Ref: EP/2/21HH

Description of Works: Erection of front extension to create first floor balcony, following demolition of existing conservatory with changes to external materials and wall finishes.
Location: 27A Sea Lane, East Preston, BN16 1NH

Front Elevation (west)

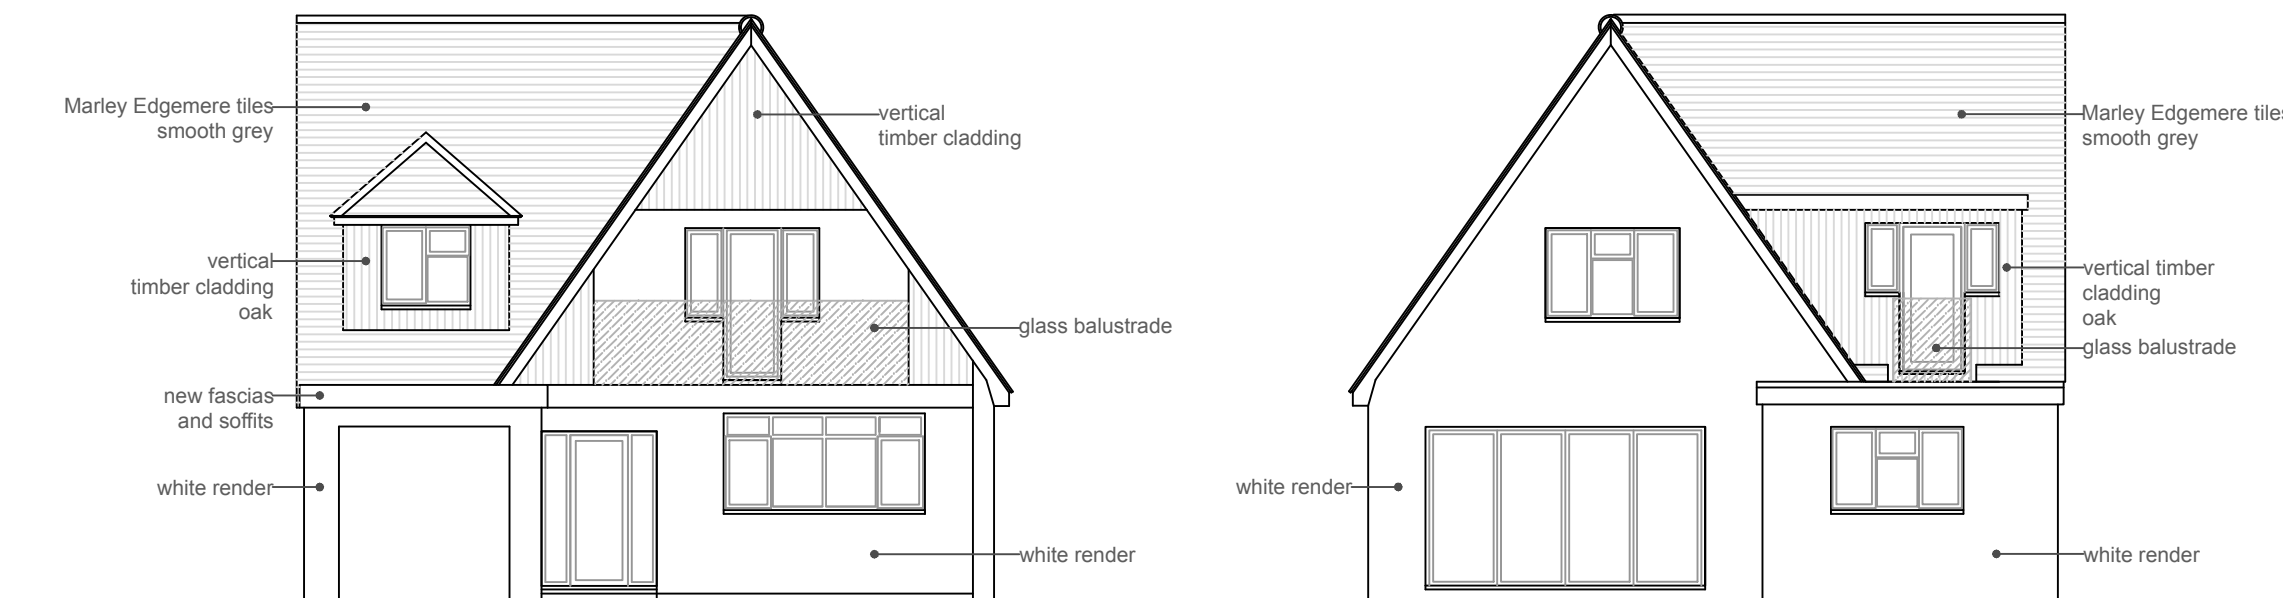
We have the following objections to the roof extension and balcony to the front of 27a because:

- ¿ The roof of 27a has already had a large extension in the past. It has a very dominant impact on our garden and our annexe. The further extension of the roof at the front would take out the last view of the sky that our Father can see from his bedroom window in the annexe and this would be very oppressive for him. (Photo 20)

- ¿ The extension of the front roof would take sunlight from the paved seating area in front of our kitchen and make the side elevation more oppressive as we sit at our garden table and as we enter by the side gate. (Photo 21)

- ¿ We have a box bedroom/study from which we can see the front window of 27a. Therefore, we believe that we will be overlooked by the new balcony. (Photo 23).

- ¿ From our living room on the ground floor we can look up, through a glass side door and sun room to the first floor of 27a. We believe we will be able to see people moving on the balcony above and they could see us. (Photo 23)

- ¿ The new roof which will form the proposed balcony to the front of the chalet bungalow at No. 27a will bring the building line of the bungalow forward by 1.8 metres. There are no dimensions on the plan to indicate if the overall roof height will change.

Rear Elevation (east)

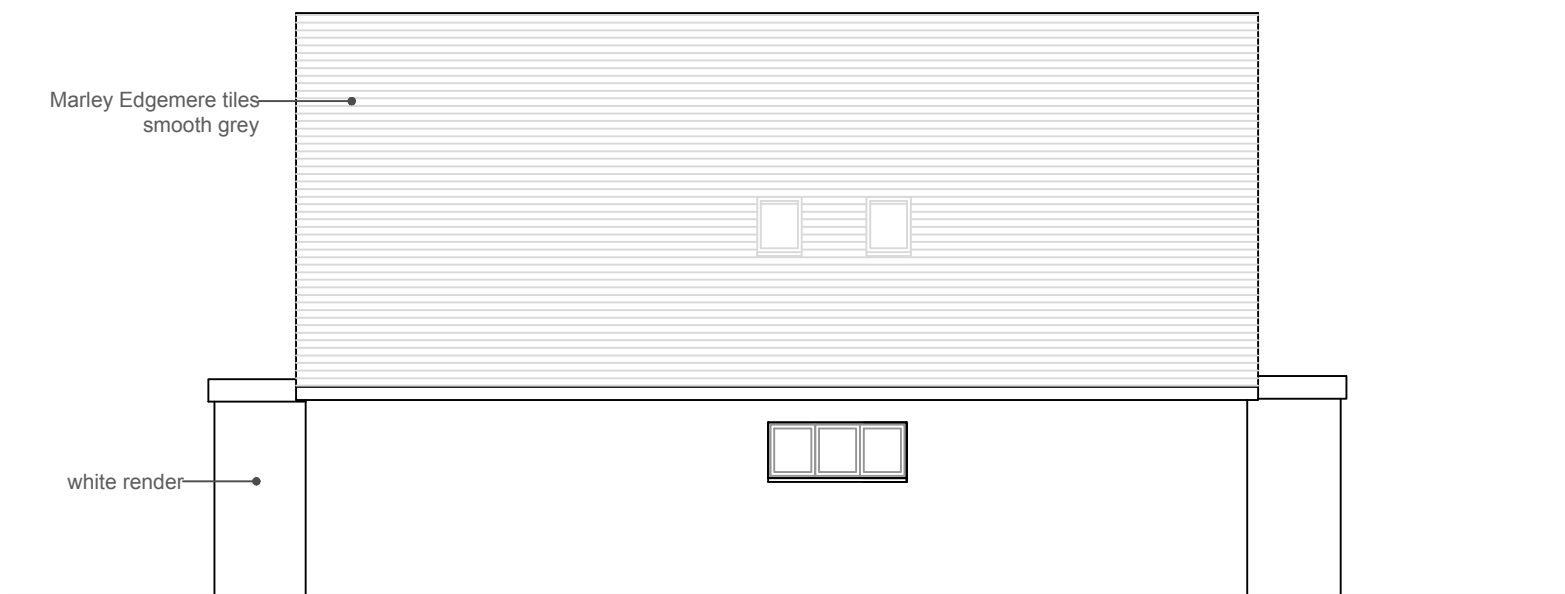
1. First Floor Balcony (east elevation) to rear of 27a

We have the following objections to the rear balcony on the grounds that:

- ¿ It is not a permitted development and it needs planning permission. The rear balcony proposed at 27a is not included in the Description of Works but is drawn on the plan. The drawing shows a balcony at the rear and replacement of the bedroom window with patio doors.

- ¿ It is very close to our boundary and would provide a seating area for several people elevated above our garden with a full view of it.
- ¿ It directly overlooks an annexe which is occupied by our Father. From the balcony you would be able to look directly into his living room through his double patio doors and also into the kitchen. It will take away all the privacy he has and affect his wellbeing. (Photos 1-5 and impact plans)

- ¿ It would directly overlook our back garden, which would affect our wellbeing and enjoyment of our garden. (Photos 6-14 and impact plans).
- ¿ It would overlook an established patio area that we use to sit out (Photos 6/7 and impact plans).

- ¿ People standing on the balcony will be able to look back into our first floor bedroom window. (Photo 15).
- ¿ People standing on the balcony will be able to look back into our kitchen window. (Photo 16).

Side Elevation (north)

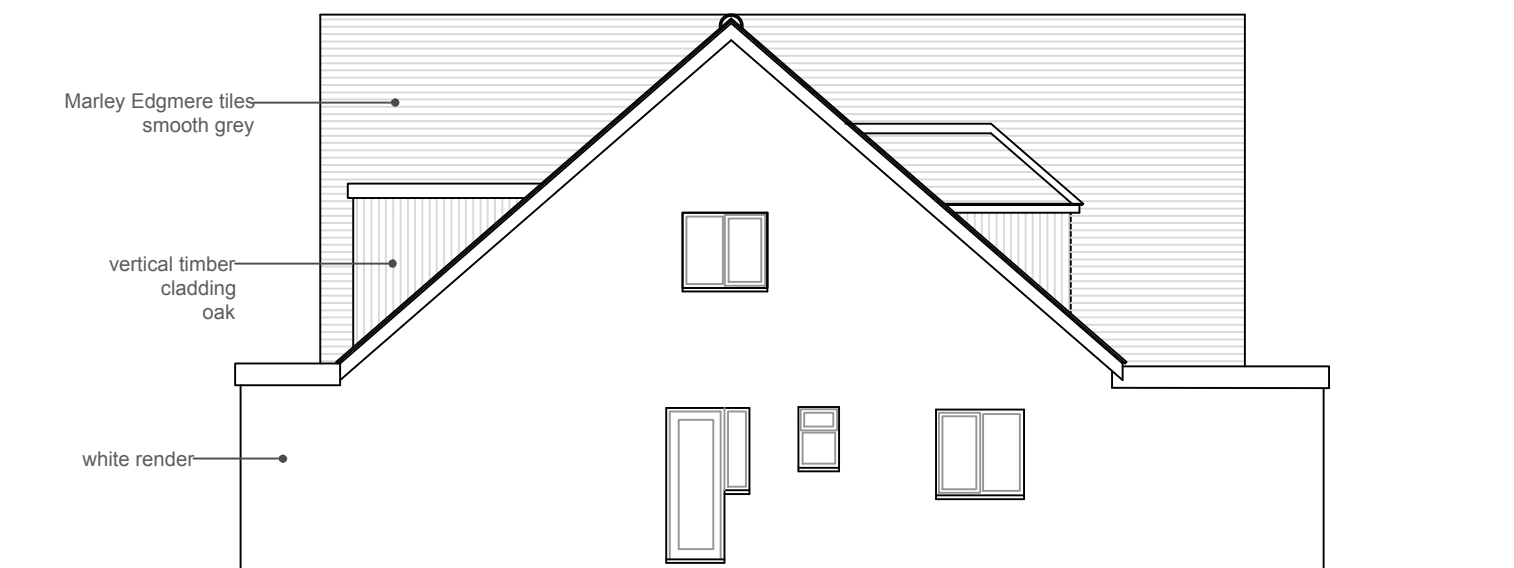
We have concerns about this elevation as it dominates a third of our garden, is parallel to the annexe and overlooks all the windows of the annexe. Changes to this elevation will impact us because:

- ¿ The first floor window on the north elevation of 27a directly overlooks our paved seating area. This window should continue to be obscure glass with the same opening configuration. (Photo 19). This was specified in a previous planning approval.

- ¿ An entrance door has been moved from the south elevation of 27a to the north elevation opposite the kitchen in our annexe. The current hedge is thinning and the fence is lower at this point. (Photo 18).

- ¿ Movement of the entrance door will mean more traffic through a narrow sideway near our paved seating area. The door will open onto a utility room and could provide an alternative way to enter the property.

- ¿ The use of white render, grey roof tiles, timber cladding (colour not defined) and new glazing (colour t.b.c.) will be more stark and confusing to the eye than the current brown hung tiles, and tiled roof, which blend in with trees and vegetation. (Photo 17).

- ¿ White render is more liable to discolouration than hung tiles. Cladding will require maintenance.
- ¿ A soil pipe will doubtless appear on this elevation where there has been none, this is not shown on plans.
